Epping to Thornleigh Third Track Proposal. Application number SSI 5132.

I/~~we~~ object to the Epping to Thornleigh Third Track Proposal and consider that the EIS is inadequate and does not address the full impact of this proposal. It will cause untold damage to the health of residents and to the fabric of the Beecroft Cheltenham Heritage Conservation Area. Do not approve this project, reconsider the alternatives and protect the community.

Figure S.6 Cross-section and elevation - New Cheltenham Station concourse building (see also S.5 for artist's impression)

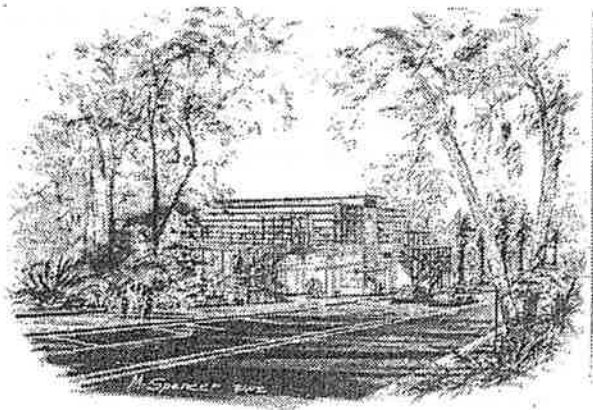
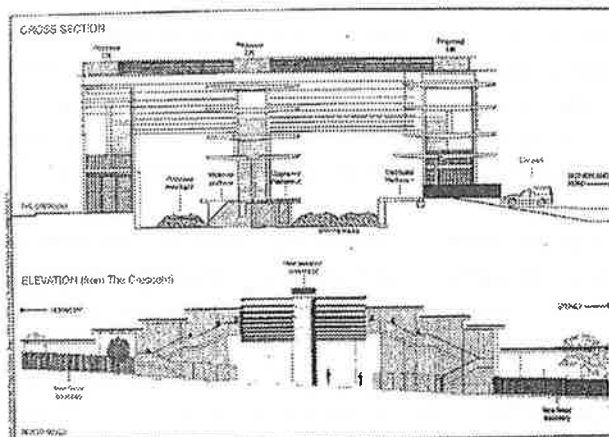
- The proposed redevelopment of Cheltenham Station shows no regard for the HCA. The visual impact of the proposed 13m high glass and steel concourse is totally unacceptable in this HCA.
